Item No. **Report of the Head of Planning, Transportation and Regeneration**

Address LAND TO REAR OF 56 BRIARWOOD DRIVE NORTHWOOD

Development: Construction of a two storey detached house with associated parking and landscaping

LBH Ref Nos: **19486/APP/2021/3500**

Drawing Number	21/3515/1	Revision
Date	14 / 9 / 21	
Scale	1:200 @ A2

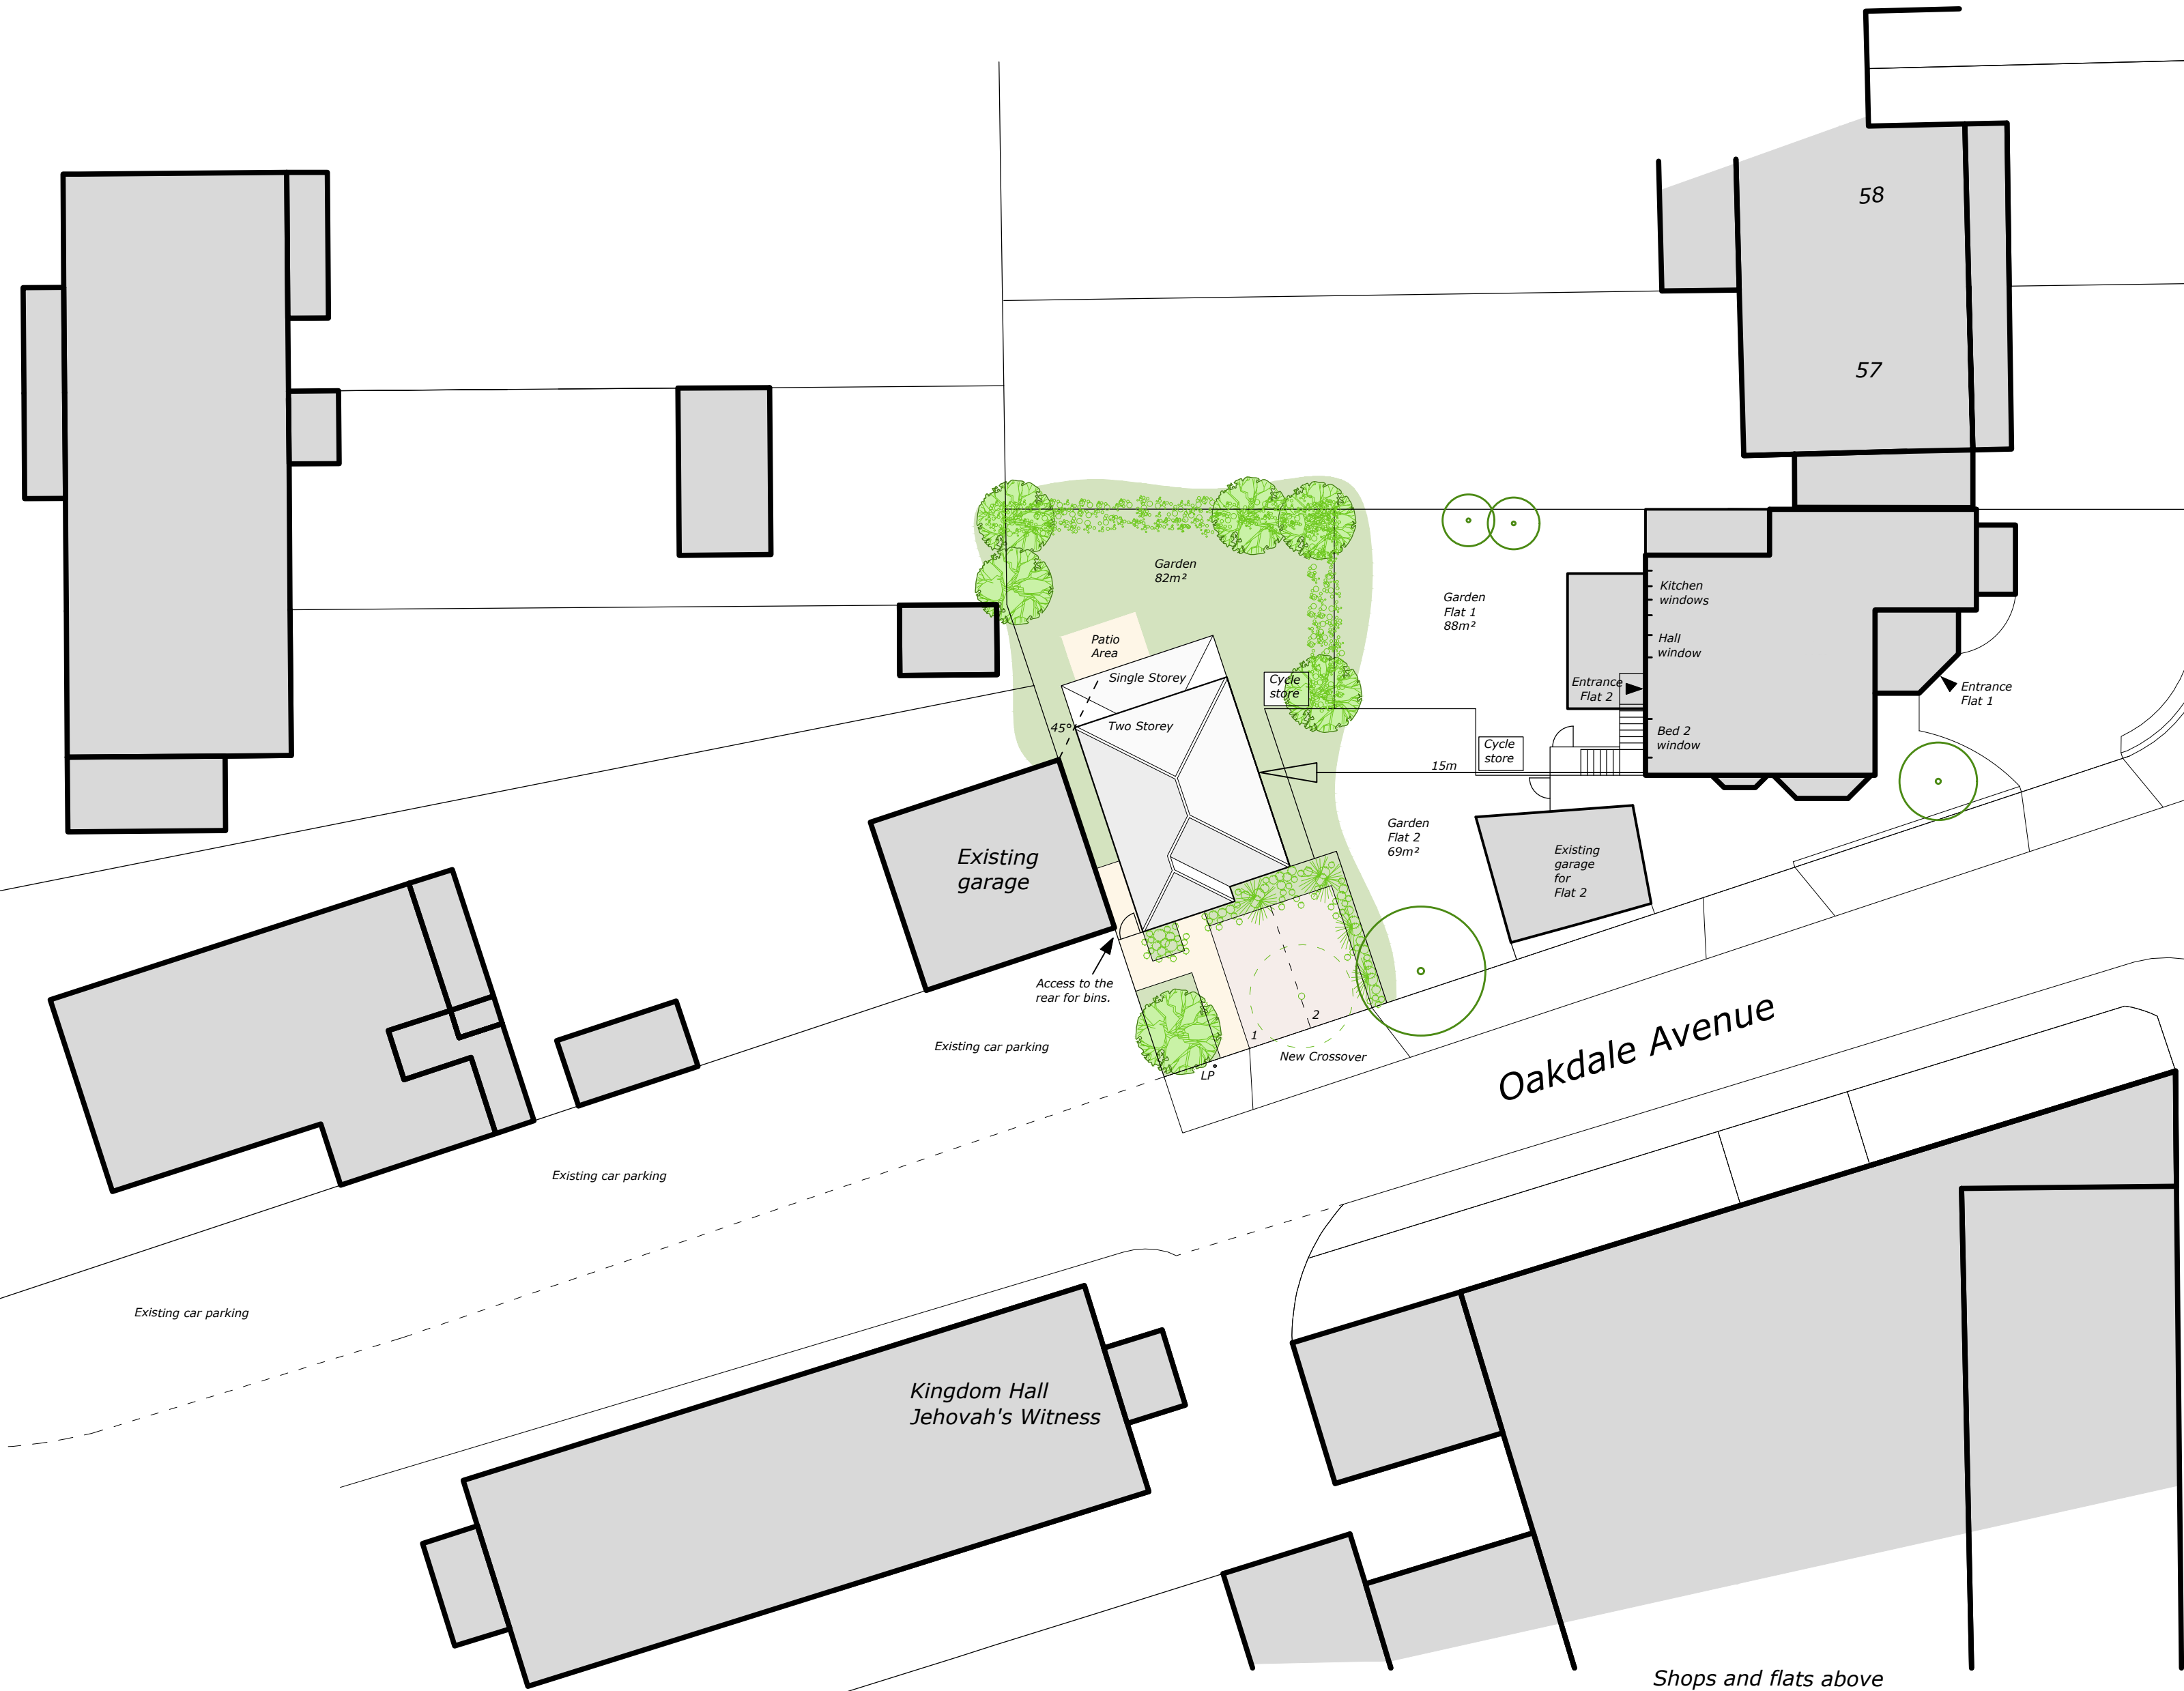
The proposed dwelling is sited in the rear garden area of nos. 56 and 56a Briarwood Drive and would be situated approximately 15m to the rear of 56a and 12m from the conservatory of no.56. At 7.6m high, the proposed two storey building situated between 12m and 15m from the rear windows of 56 and 56A Briarwood would significantly harm the residential amenities of these properties. The proposed building is even closer to their gardens and would impact adversely on views out of their amenity spaces and windows. It is therefore considered that the proposed development would have a significant adverse impact on the amenities of the occupiers of those properties, by reason of visual intrusion and a loss of outlook.

The proposal fails to follow the historic grain of the surrounding area due to its isolated backland location. The existing properties are characterised by their spacious plots and are set back from the road with ample gaps between the built forms, maintaining a sense of rhythm along the road as well as providing a sense of openness to the street scene. In comparison to neighbouring sites, the proposed dwelling and plot would be significantly smaller, with limited rear garden space, minimal frontage and no contribution to the appearance of the main road. The proposal would therefore be out of character. Furthermore due to its narrow front elevation the dwelling would be at odds with the much wider frontages of other properties which characterise the area. The infilling of the gap (between Briarwood Drive and Pinner Road), which at present provides an important break in the built form would appear out of character with the pattern, scale and form of development within the surrounding area. Therefore in principle this form of development is considered unacceptable.

Drawing Number	Revision
21/3515/2	
Date	
20 / 5 / 21	
Scale	
1:100@A2

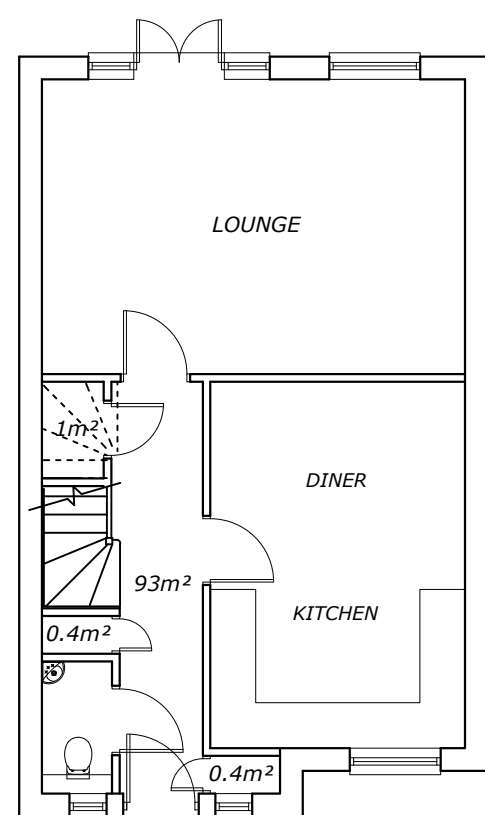
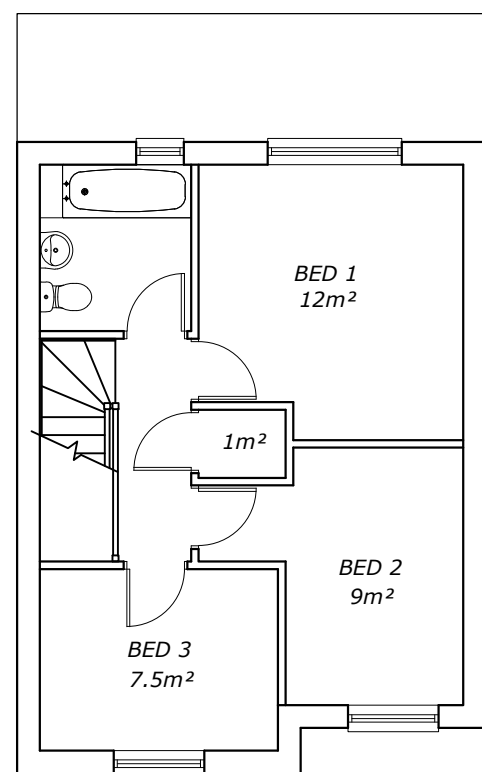
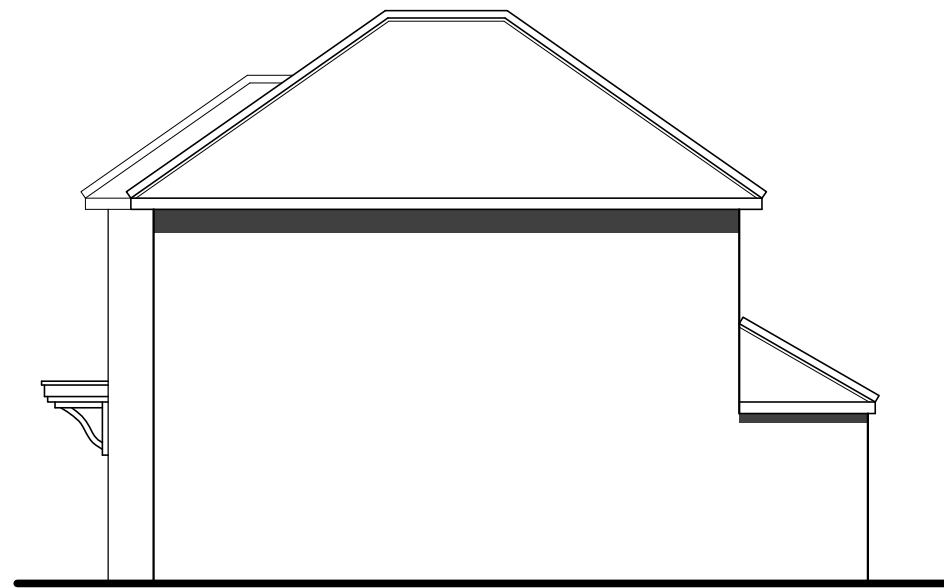
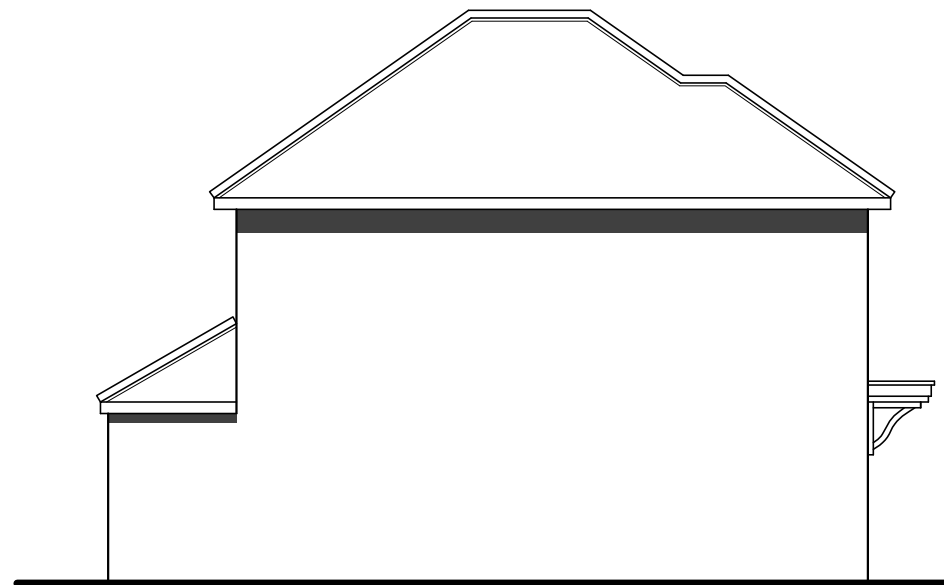
The proposed building is approximately 7.6m high, 6.2m wide and 10m deep. it would be finished in brick, with two storey front bay and hipped roof.

'This proposal for a single dwelling house raises accessibility concerns. Policy D7 of the 2021 London Plan requires all new housing to be designed and constructed as accessible and adaptable in accordance with M4(2) as set out in Approved Document M to the Building Regulations (2015 edition). Revised plans should be requested prior to any grant of planning permission to address the following issues. 1. Step free access into the

dwelling is required. Details should be submitted to satisfy the above policy requirement.

2. The entrance level WC shown on plan does not meet the requisite space standards or provide the required clear access zones for such a cubicle in a three bedroomed house

3. Particular attention should also be paid to the entrance lobby arrangement and to spatial requirements within the bedrooms, bathrooms and kitchen area. The plans should be amended accordingly to demonstrate compliance with the technical specifications within Approved Document M to the Building Regulations (2015 edition). Conclusion: unacceptable. Revised plans should be submitted prior to any planning approval.'
